## TRANSPORT ASSESSMENT ADDENDUM

Project:	Land off Ploughley Road, Ambrosden, Oxfordshire – 22/02866/OUT	Page 1 of 6
Subject:	Site Access Arrangements	Date: 02/12/2022

Technical Note Prepared by:	Approved for Issue by:
Christopher Miles <b>Transport Consultant</b>	Max Thurgood <b>Director</b>

PROPOSED CYCLE ACCESS
SCALE 1:100

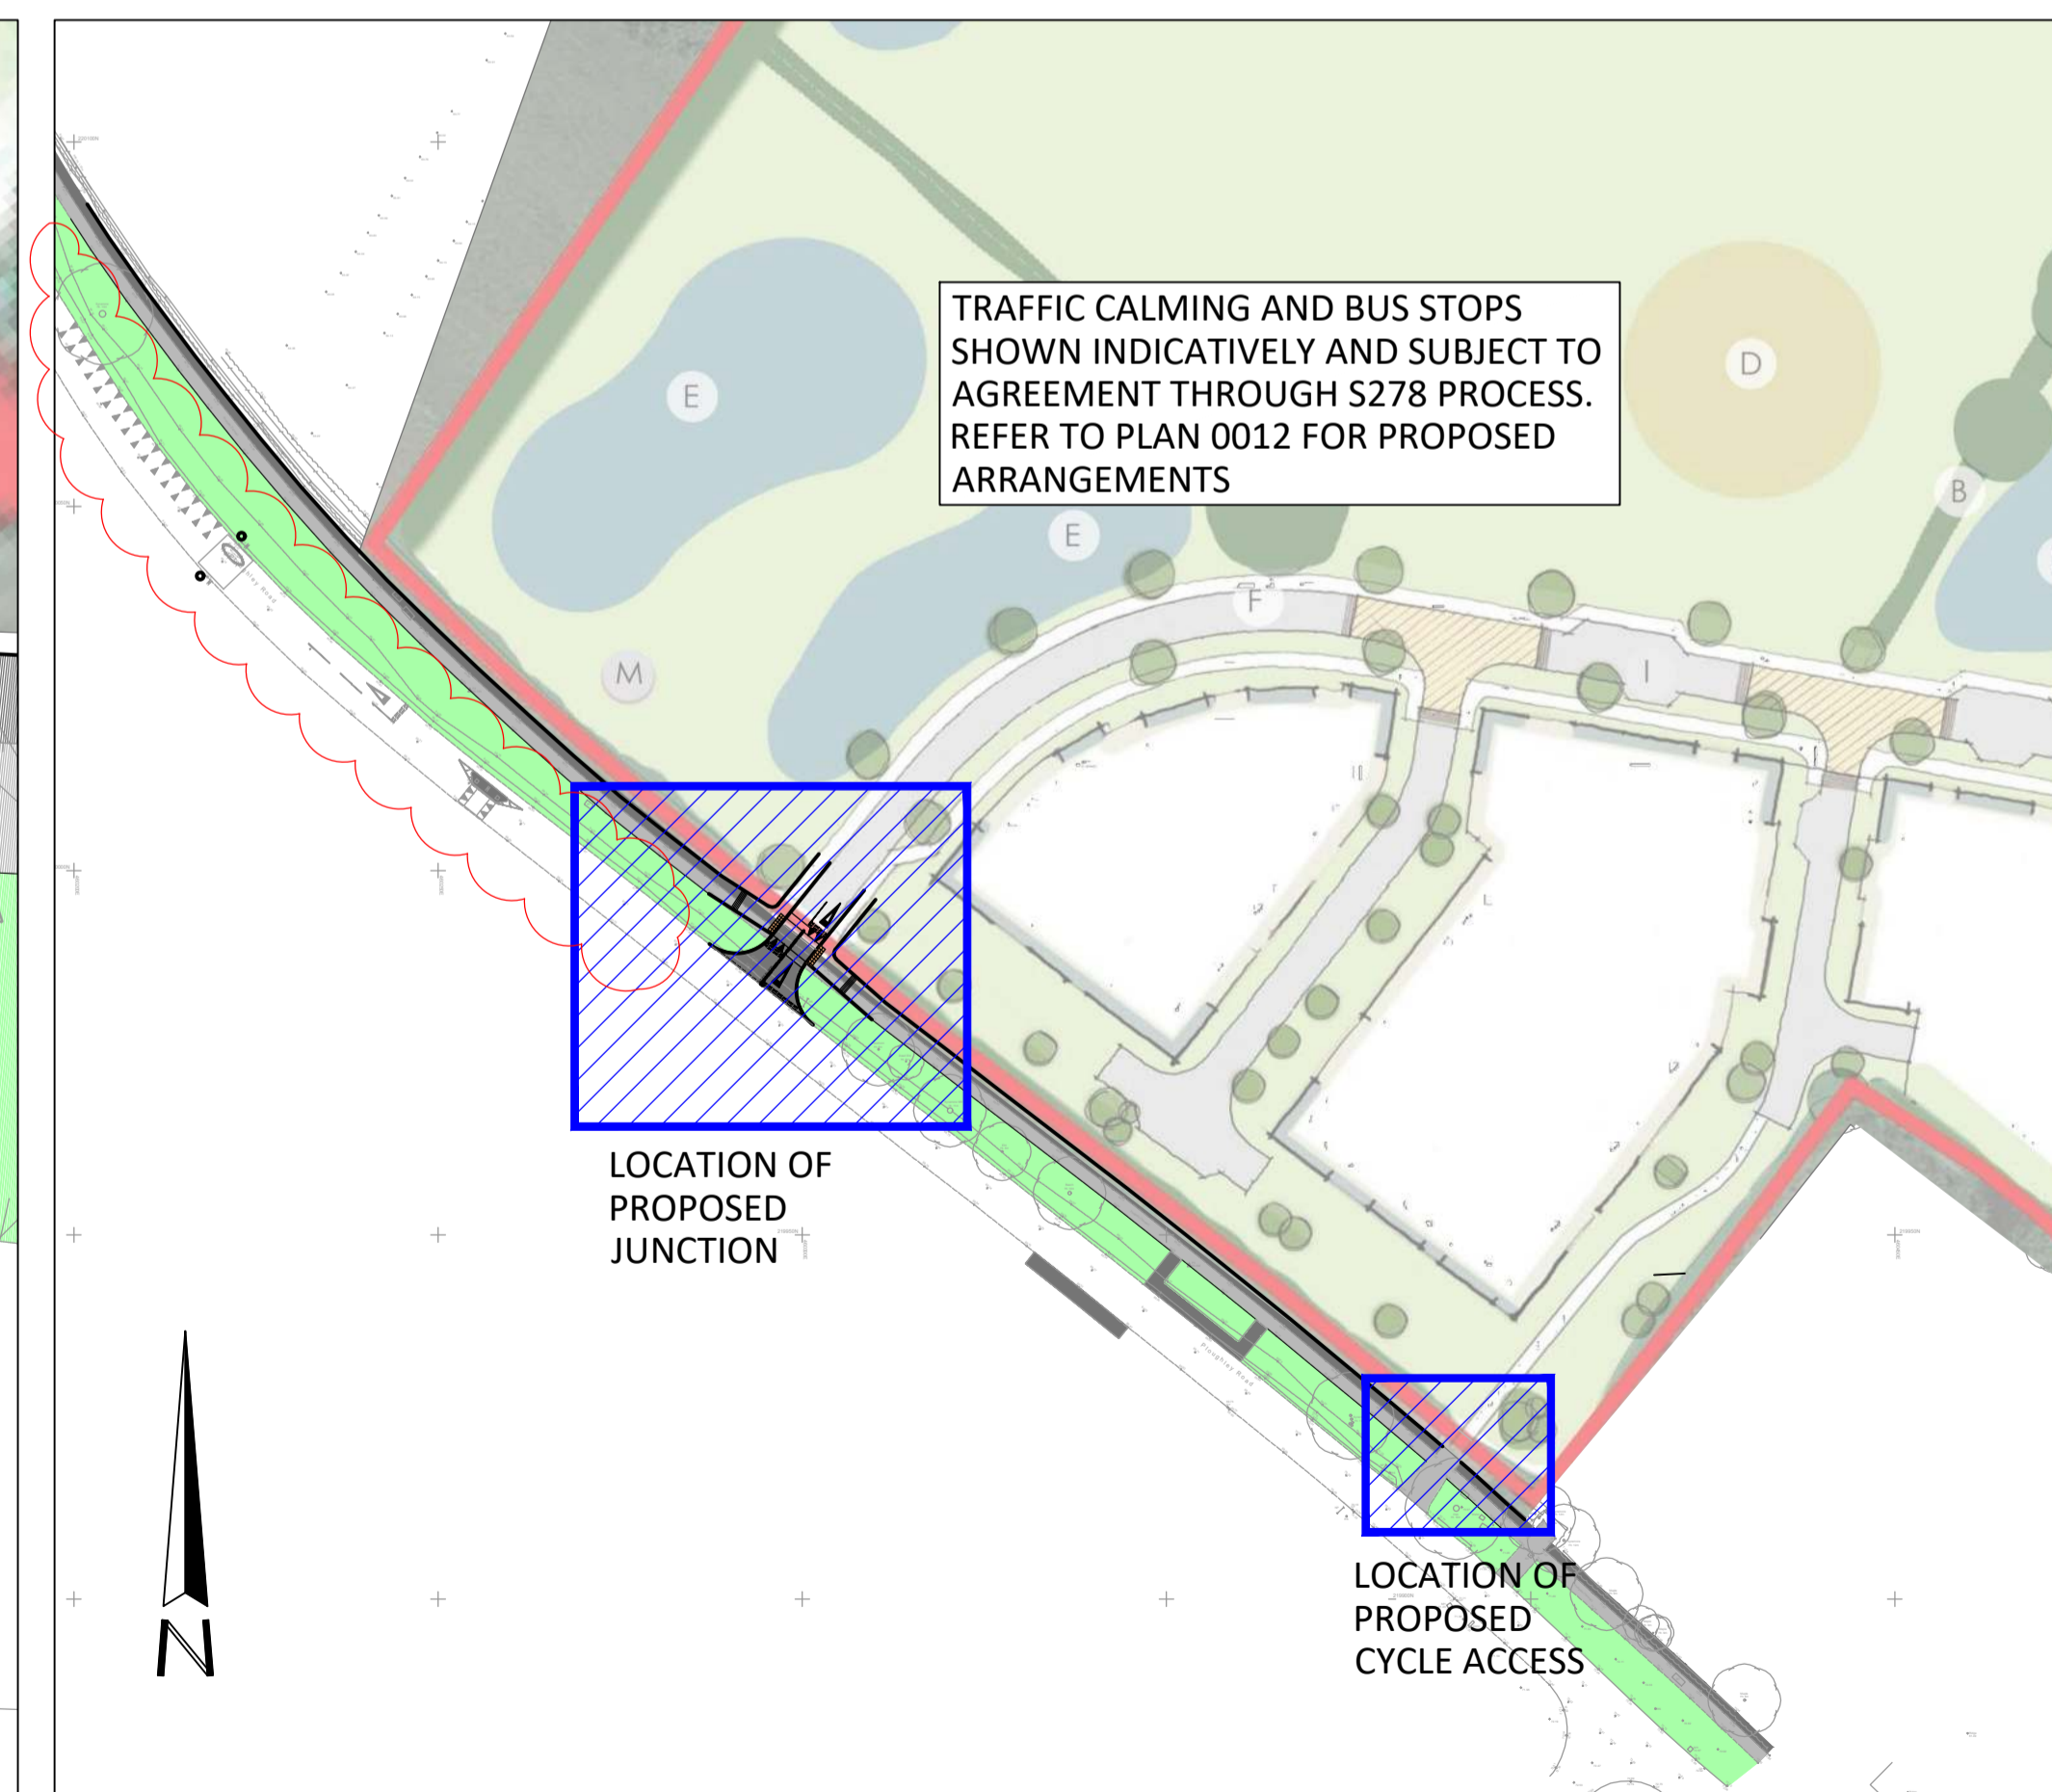
Given the above, OCC consider that the available visibility from the site access is insufficient for the anticipated vehicle speeds along Ploughley Road, despite the proposed change to the speed limit, and this is a reason to **object**.

The bellmouth access must include a cycletrack crossing in accordance with LTN 1/20, as noted in sect. 5.3 of the TA.

Use of the formula provided within Section 10 of MfS2 identifies that a 70m splay equates to an 85<sup>th</sup> percentile traffic speed of approximately 37mph. Given the proposed traffic calming layout, the reduction in speed limit and the appropriate design guidance, it is considered that 85<sup>th</sup> percentile speeds of approximately 37mph are unlikely to be exceeded and that the 70m visibility splays shown on the revised site access plans are therefore both appropriate and acceptable.

The OCC consultation response also identifies that the bellmouth access junction must include a cycletrack crossing in accordance with Local Transport Note 1/20: Cycle Infrastructure Design. The layout of the access junction has therefore been amended to give greater priority to the existing shared use path where it crosses the proposed site access (plan 0007\_P05 in Appendix B).

The path is shown as being widened to 3m where it crosses the access road and slightly realigned into the site to increase the offset distance from the Ploughley Road kerb line to approximately 6m. This in turn allows the introduction of a raised table to give pedestrians and cyclists using the shared use path priority over vehicles entering and departing the residential development. This can also be reinforced through the provision of formal ‘give way’ road markings on the site access.

This arrangement complies fully with the LTN1/20 design guidance including the provision of appropriate car driver to cycle path visibility splays in both directions.

VEHICLE TRACK
SCALE 1:200

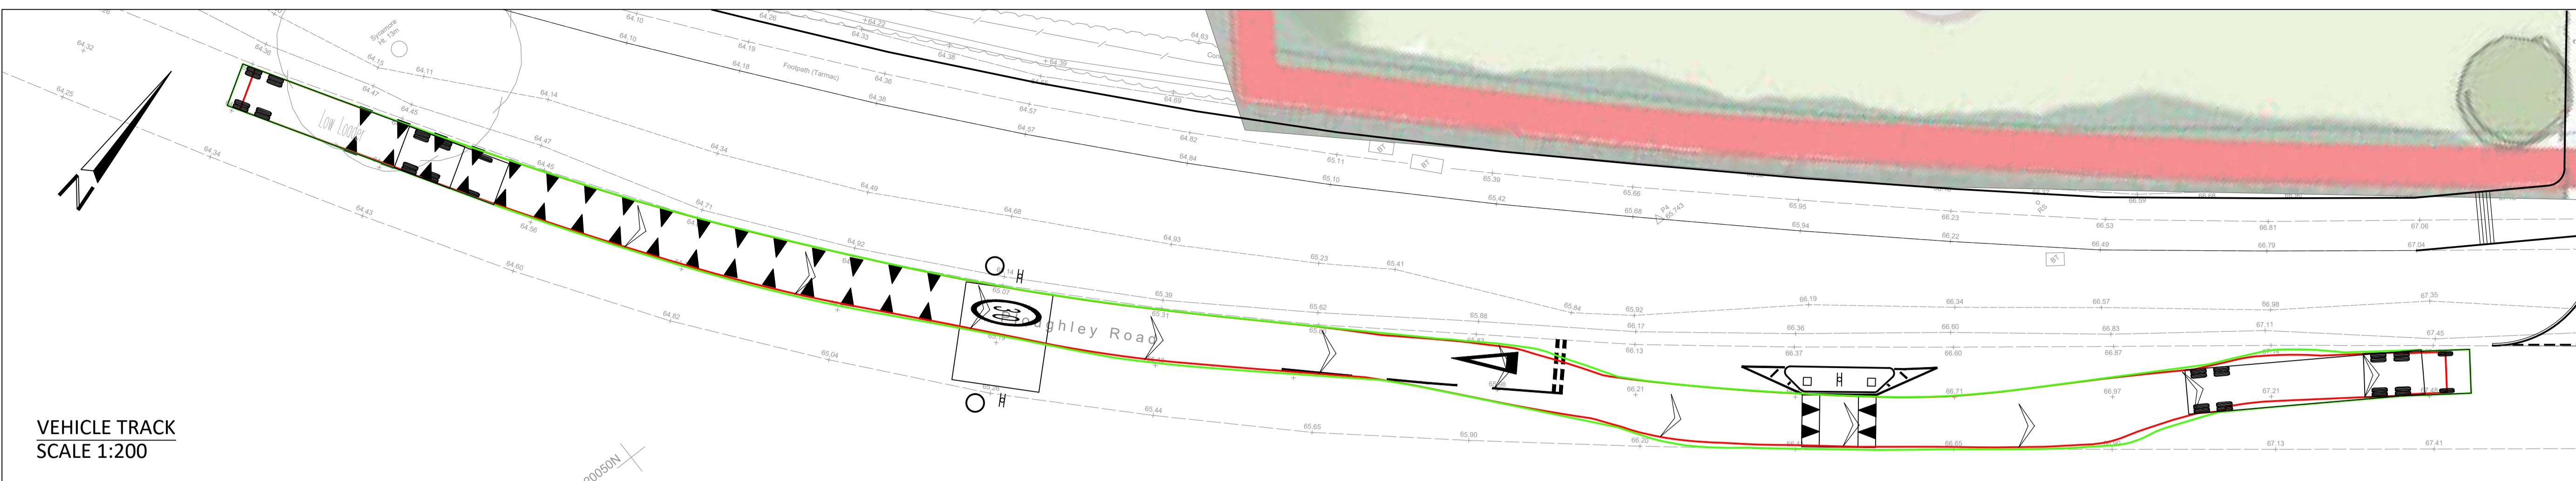
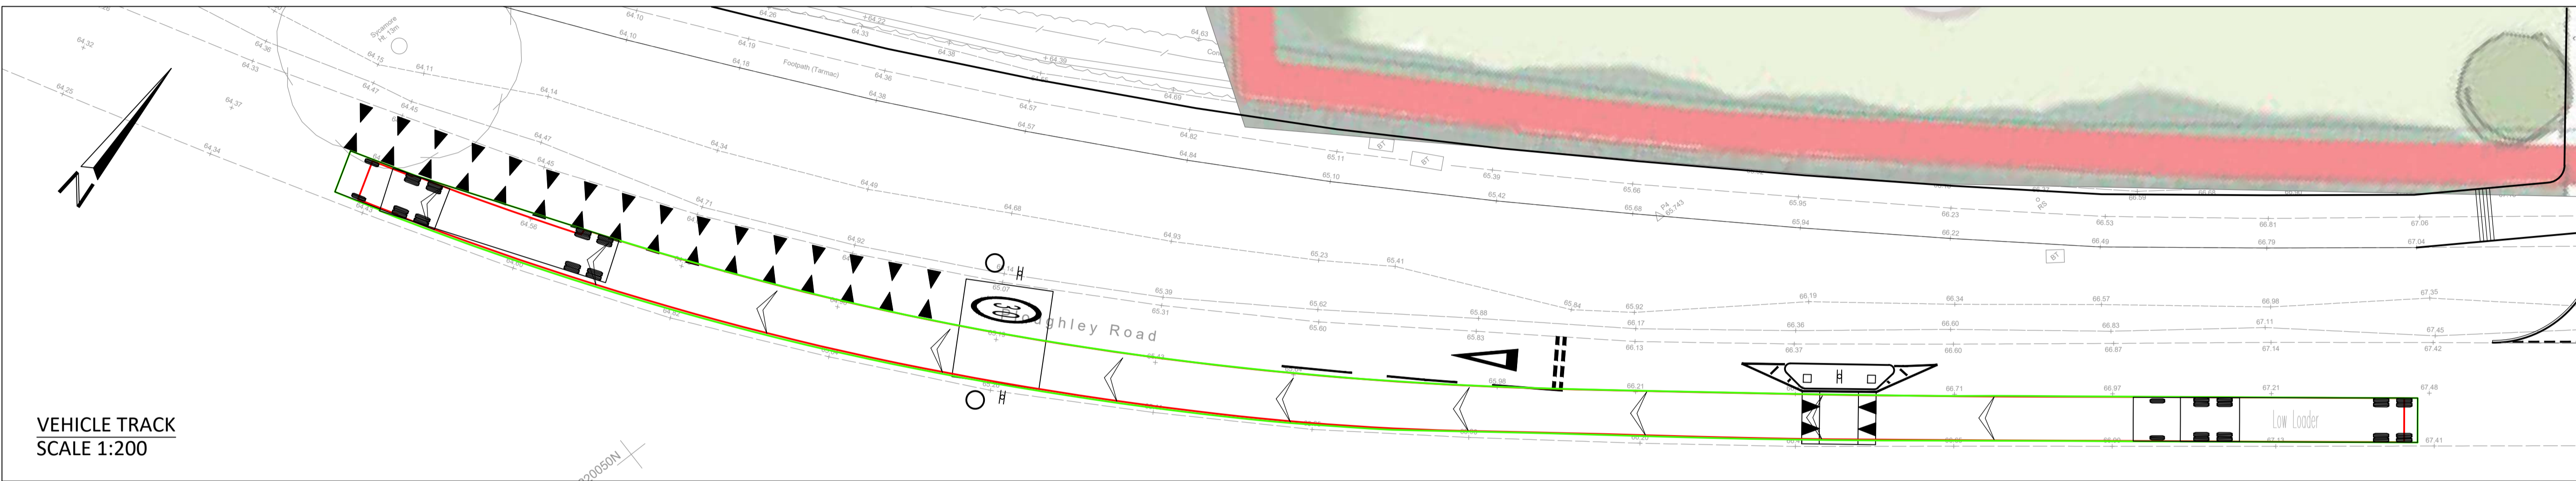
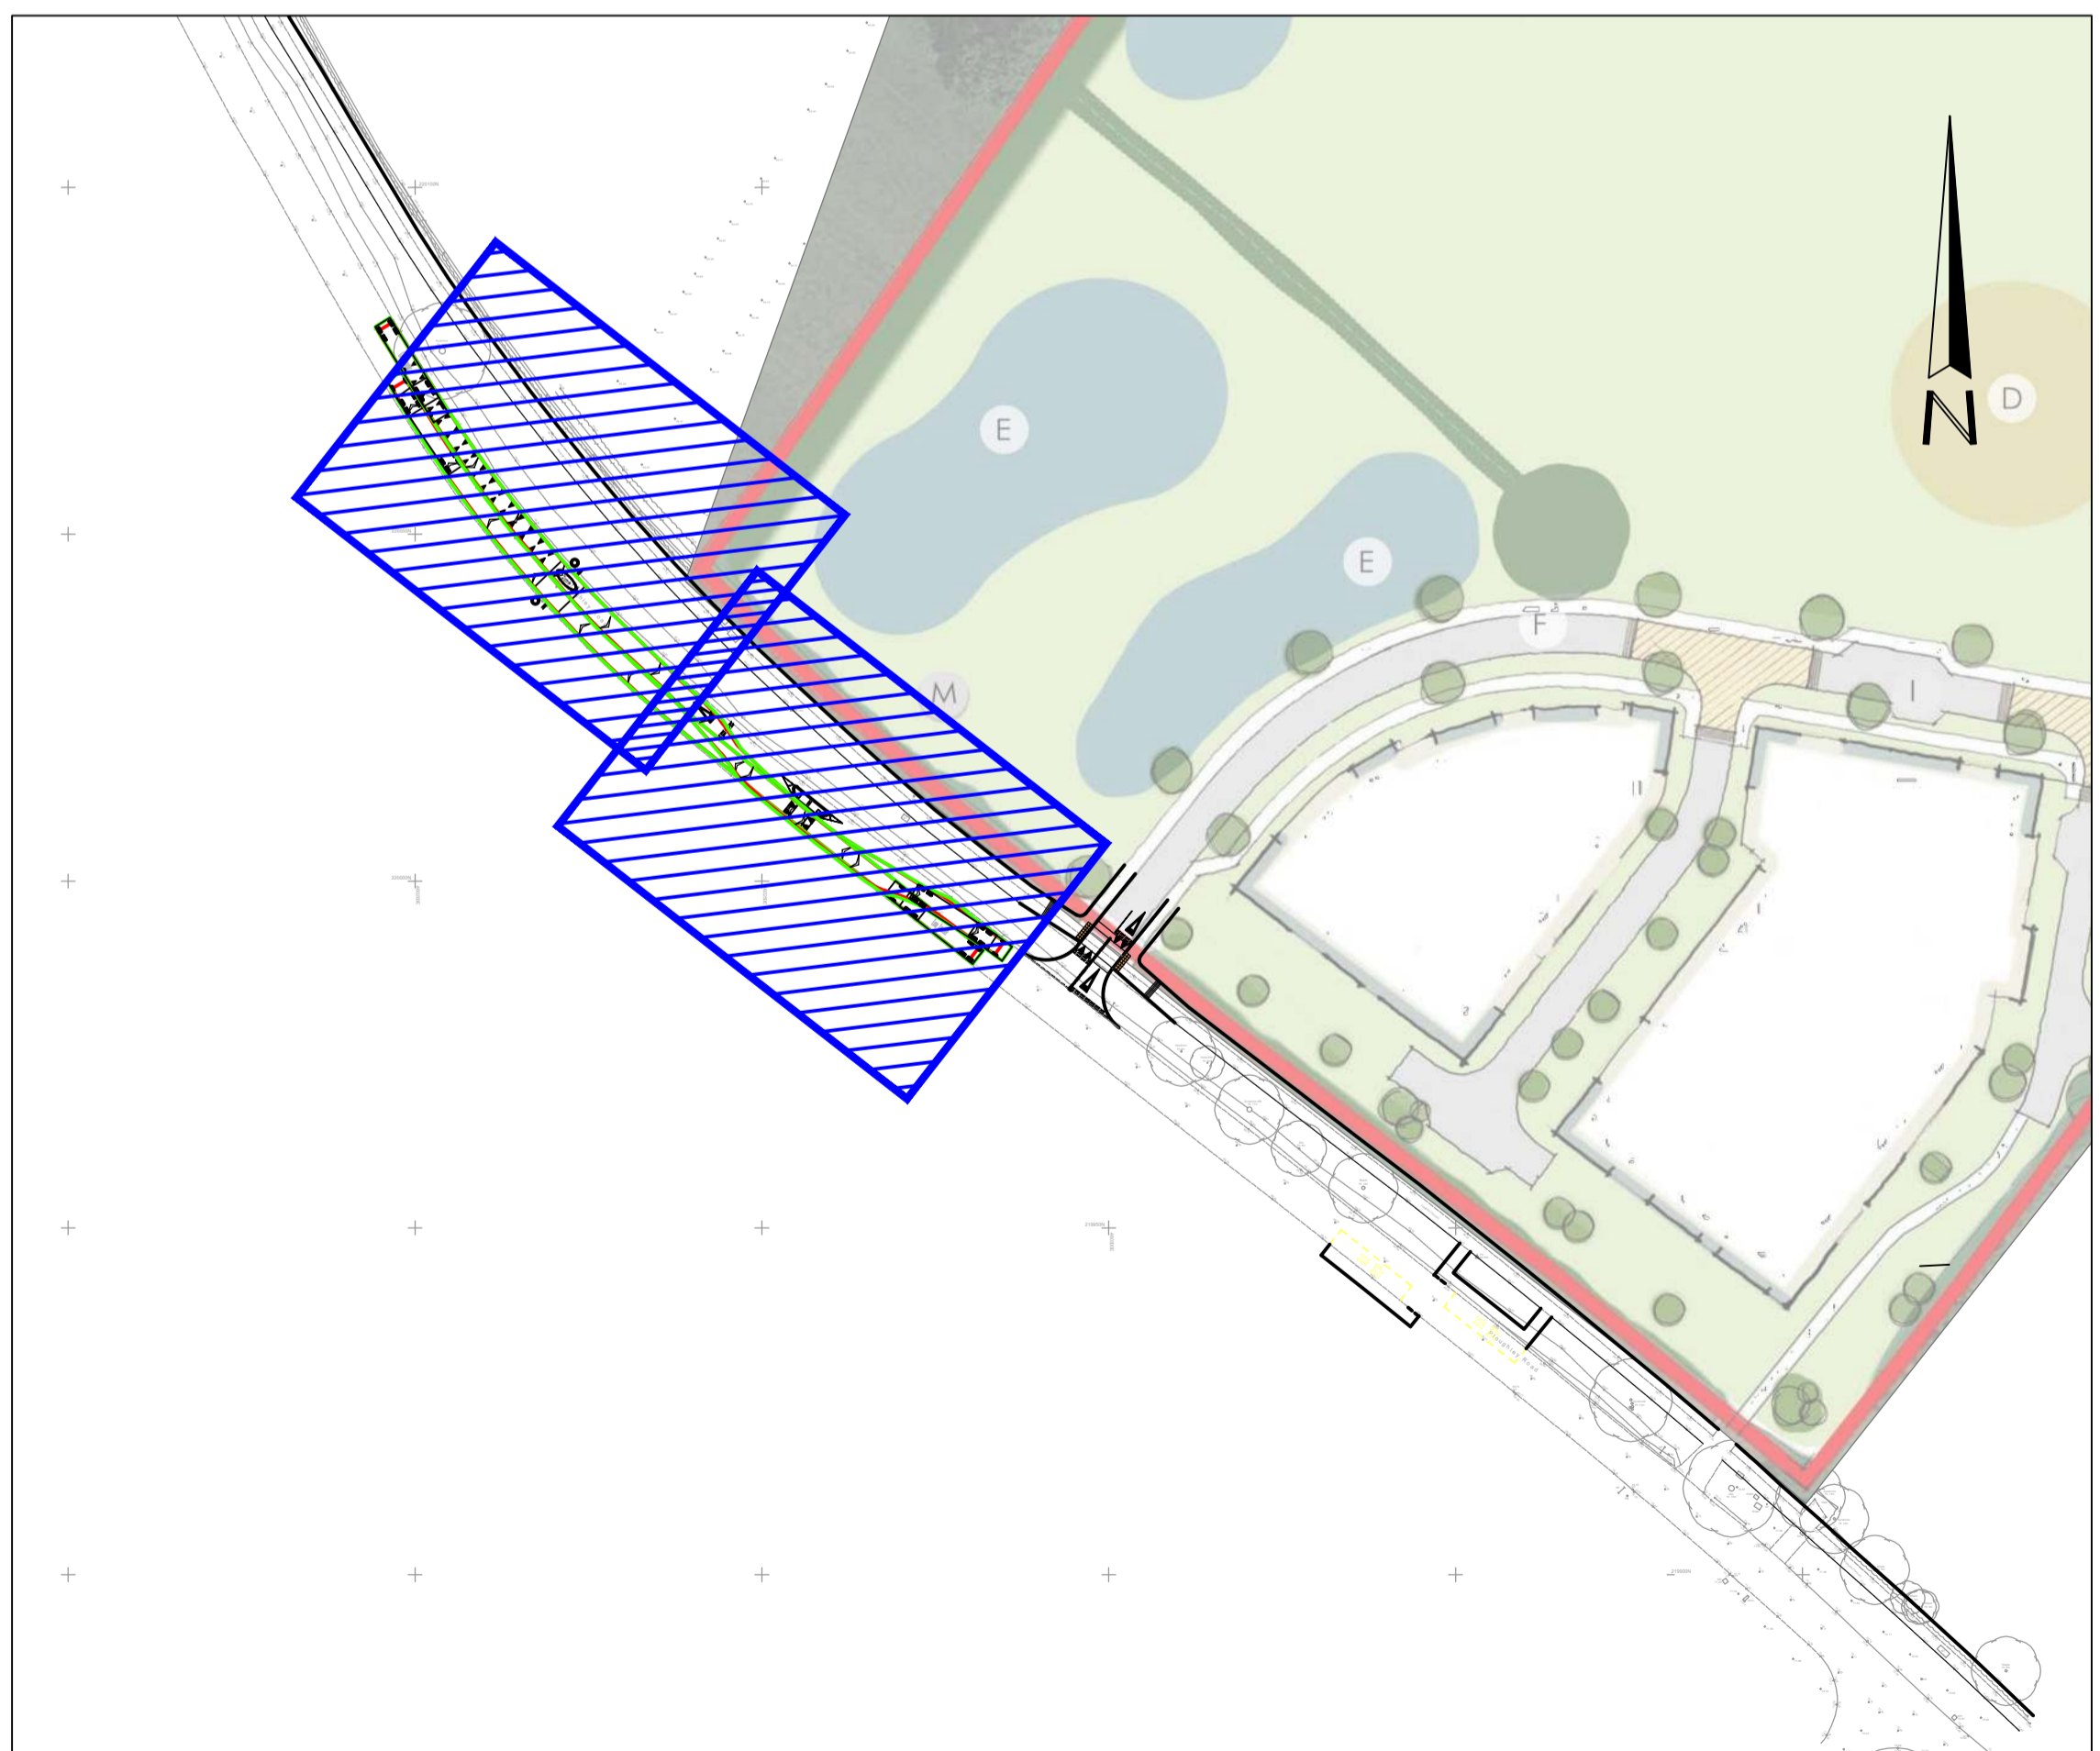
It is acknowledged that there is a large military presence in the local area including Bicester Garrison within Ambrosden itself. The traffic calming features have therefore been positioned to ensure that a large articulated low loader vehicle can pass through the features in both directions without undue difficulty, as shown by the swept path analysis.
